WEST SUSSEX COUNTY COUNCIL CONSULTATION

TO:	Arun District Council FAO: Simon Davis
FROM:	WSCC - Highways Authority
DATE:	26 March 2020
LOCATION:	Land east of Shripney Road & south of Haddan House Shripney Road Bersted PO22 9NW
SUBJECT:	BE/109/19/OUT Outline application with some matters reserved for up to 46 No dwellings together with access. This application is a Departure from the Development Plan. Updated Design Audit received.
RECOMMENDATION:	No Objection

Proposed Site Access Arrangements

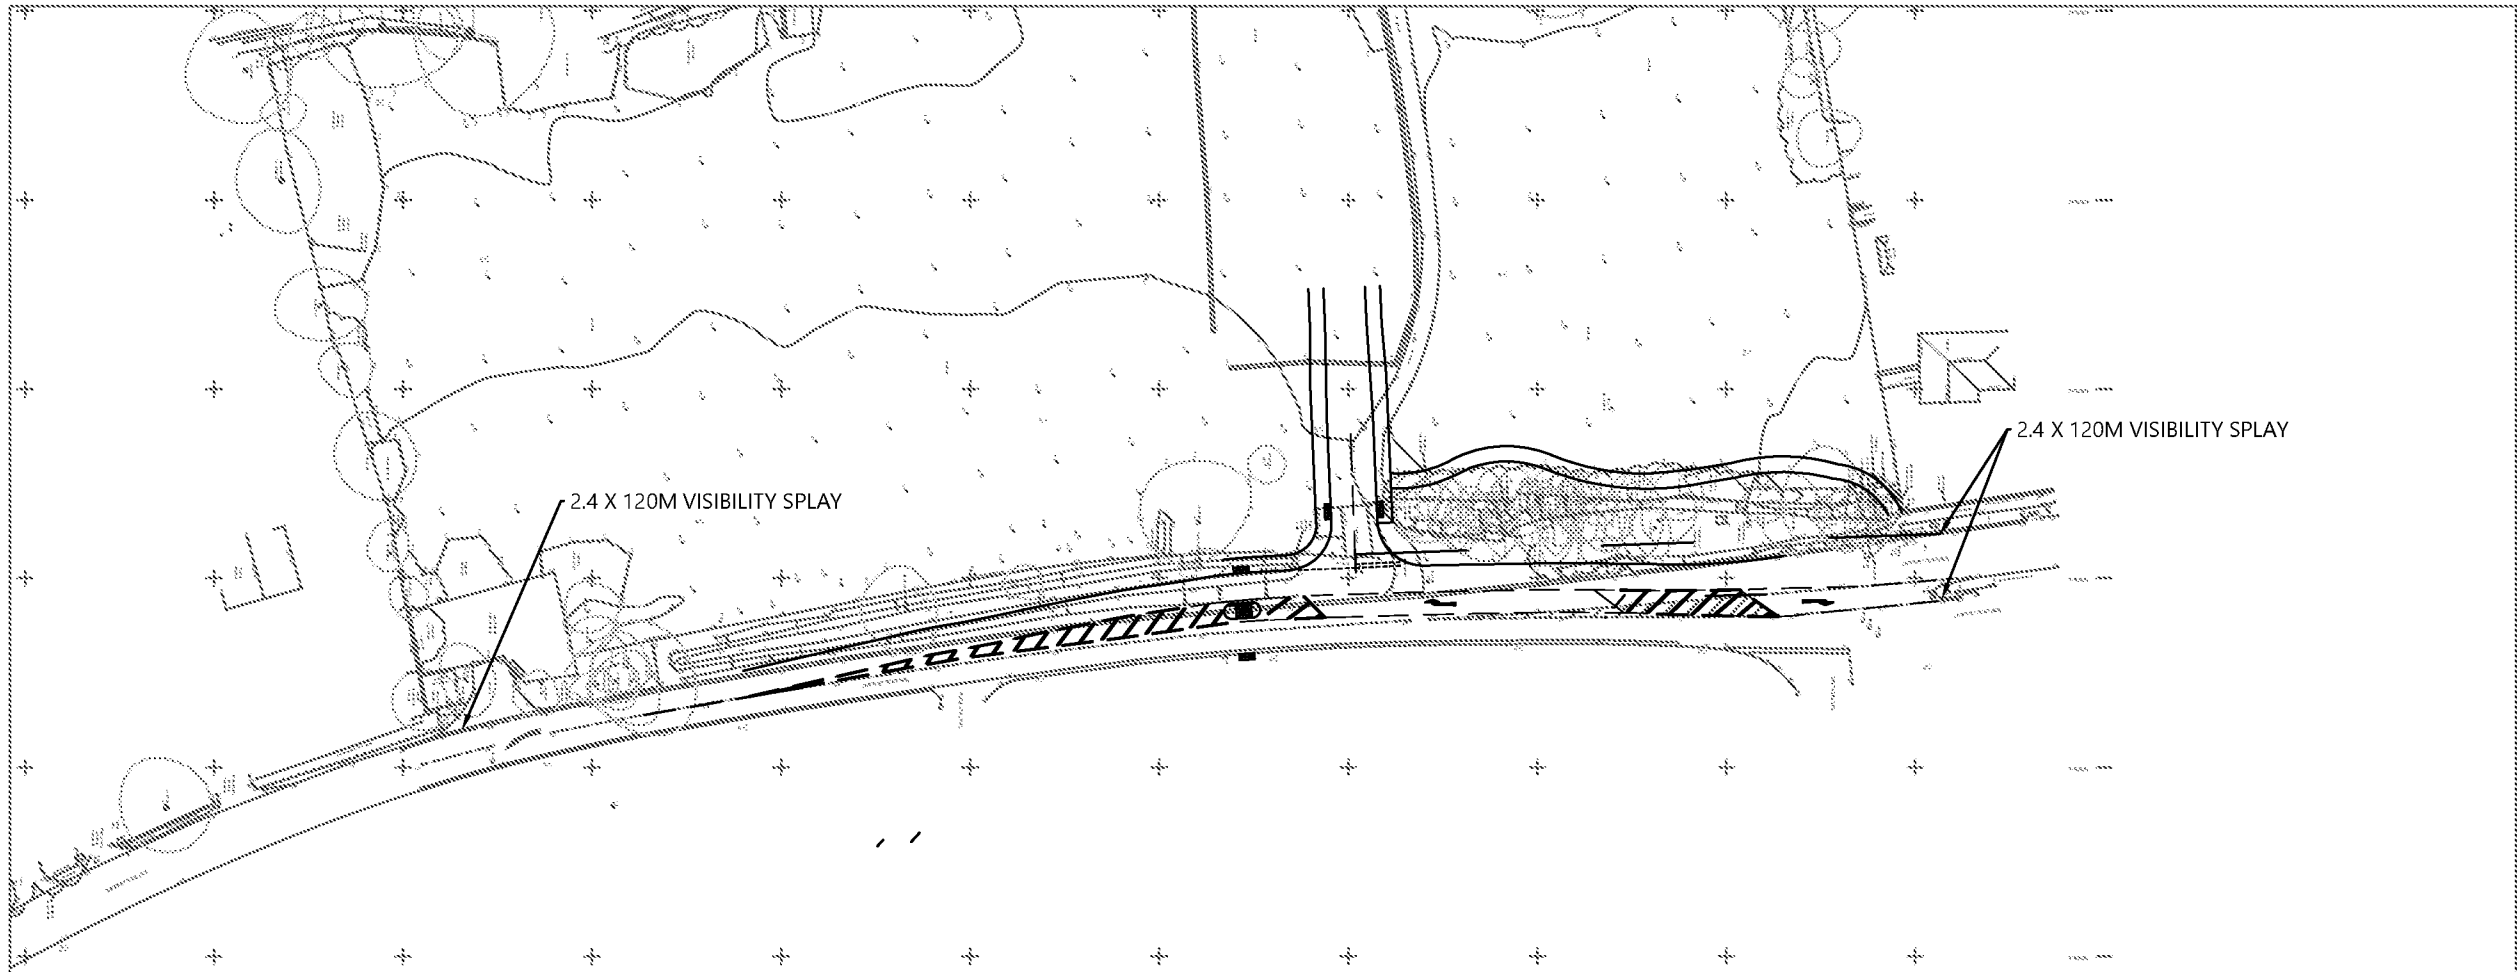
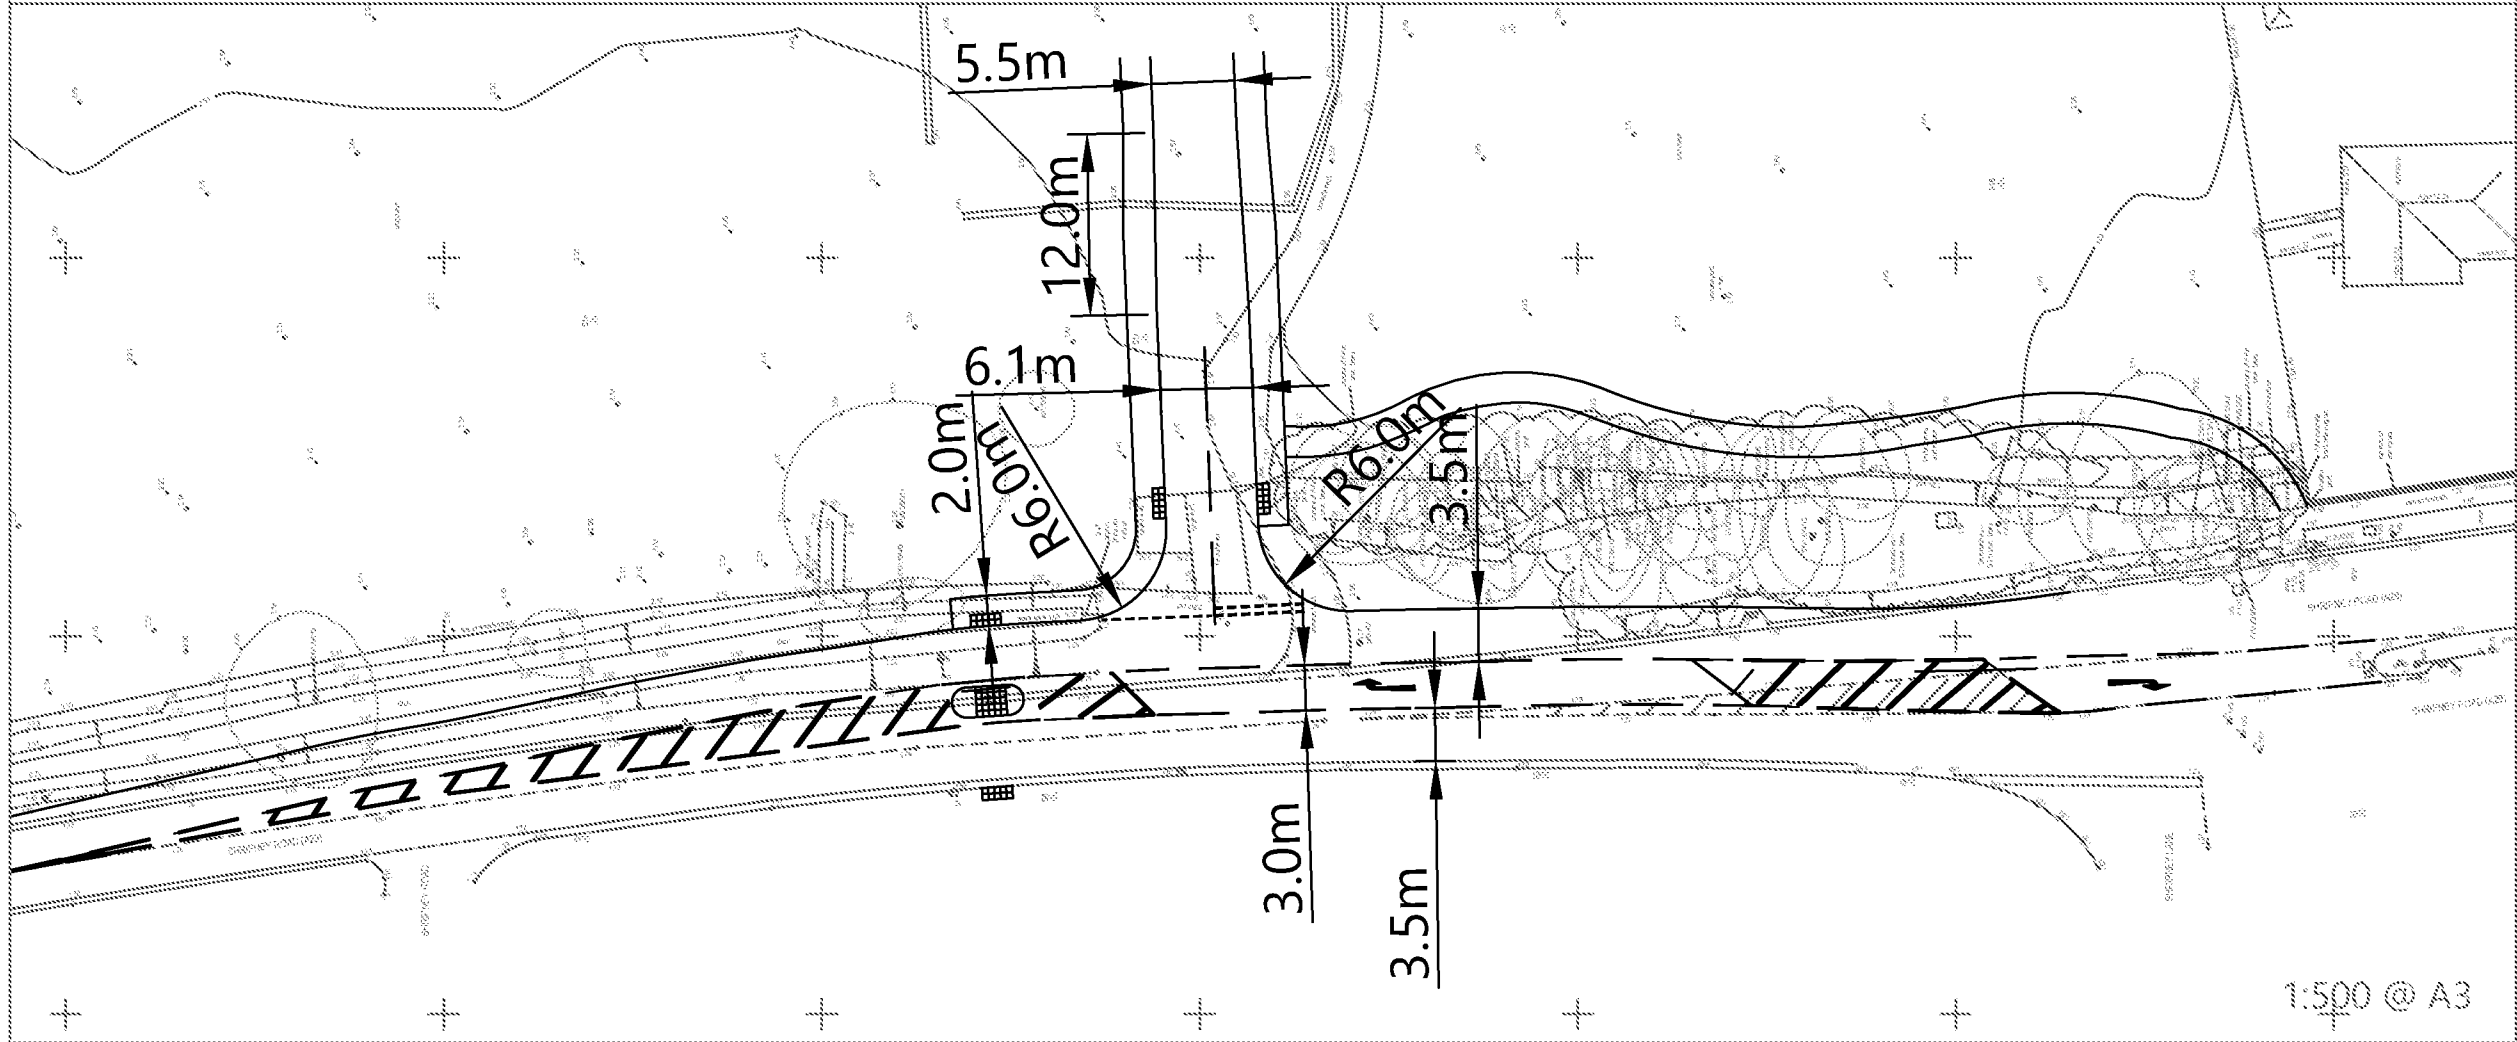
- 1845/DfS/01/B: Y-distance – It has been accepted that the southern splay can be taken to a 0.5m offset from the nearside kerbline of the northbound carriageway, considering anticipated track of vehicles and full envelope of visibility will not be obstructed.

- 1845/DfS/05/B: Shripney Lane Hatching - At the modified junction of Shripney Road and Shripney Lane, the approach lane is circa 3.4 metres at the tip of the associated hatch marking, instead of 4 metres as per the standard. There is insufficient carriageway width to provide this yet swept path tracking shows vehicles can still manoeuvre junction without overrunning hatching or Refuge Island at the junction and hatching is considered to guide vehicles away from Refuge Island.

- 1845/DfS/06: Insufficient deceleration length (Shripney Road central treatment/hatching) - a minimum deceleration distance of 41.7 metres and a direct taper of 15 metres should be provided based on design speed of 71.7 kph with a gradient in 0-4% range. A deceleration length of 33 metres and direct taper length of 5 metres for the site access junction are proposed as there is

insufficient junction stagger to provide deceleration and taper lengths in accordance with the standards. Shripney Road in the vicinity of the site access is fronted by residential properties, a frontage road, a public house and hotel. Some of these properties require vehicles to turn right without a right turn lane and thus decelerate fully within the running lane. The existing Shripney Lane junction also requires vehicles to begin decelerating within the running lane. Relocating the proposed site access to the north would increase the safety implications at the existing Shripney Road frontage road junction opposite (circa 50m north of the access). Consequently, the DfS has been accepted.

No part of the development shall be first occupied until such time as the vehicular access and associated works serving the development has been constructed in accordance with the details shown on the drawing titled PROPOSED ACCESS ARRANGEMENTS AND SHRIPNEY ROAD PEDESTRIAN CROSSING IMPROVEMENTS and numbered 1845-09 Rev B.

No part of the development shall be first occupied until visibility splays of 2.4 metres by 124.2 metres to the south and 2.4 metres by 120 metres to the north have been provided at the proposed site vehicular access onto Shripney Road in accordance with the approved planning drawings. Once provided the splays shall thereafter be maintained and kept free of all obstructions over a height of 0.6 metre above adjoining carriageway level or as otherwise agreed.
